File No: R/2017/23/C & /2019/16/B
Our Ref: 2020/545943
Your Ref: SSD-8875 MOD 1 & SSD-10375

Request for advice – SSD 8875 MOD 1 Envelope Amendments and GFA Increase & SSD 10375 (Pitt St North) Stage 2 Development Application – Advice on RTS

Thank you for your correspondence dated 20 November 2020 seeking the City of Sydney's (the City) comments on the Response to Submissions (RtS) for the proposed amendments to the concept approval and the above detailed design for the Pitt Street North OSD at 175-183 Castlereagh St, Sydney.

Figure 31 | Car stacker and Loading dock layout (Source: RtS)

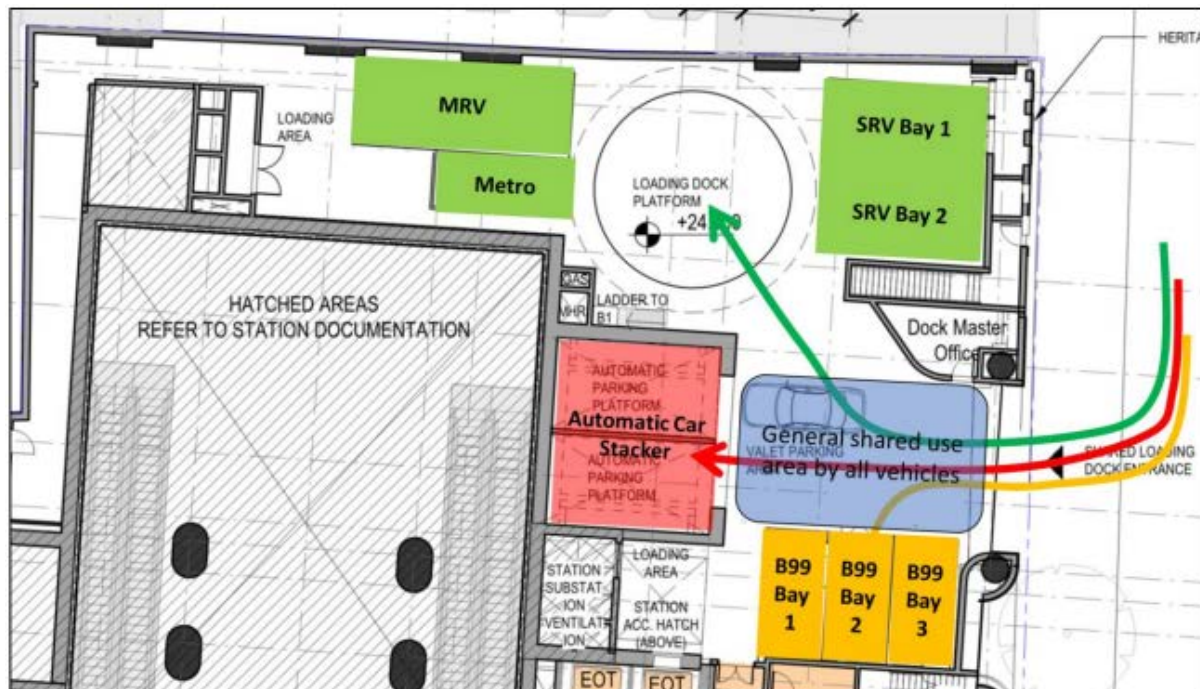
Overall there is still some concern regarding the access arrangements. The current proposed access arrangements require vehicles waiting for the lifts (and entering and exiting the lift) to use the shared space and impact on access to the loading areas. Access to the site for loading and servicing should be prioritised. A queuing assessment is also recommended to use the Australian Standard 98th percentile for access to mechanical parking installations. This site is in a busy city centre location, on a road with bus priority lanes and high use from people walking, people cycling, public transport and vehicles.

Further, any safety measures that impact negatively on the public domain are not supported. Pedestrians using the footpath must have priority over vehicles entering and exiting the site and the site should be designed safely and so that this priority is maintained and clear. Castlereagh Street footpath is busy and will become busier with the opening of the station.
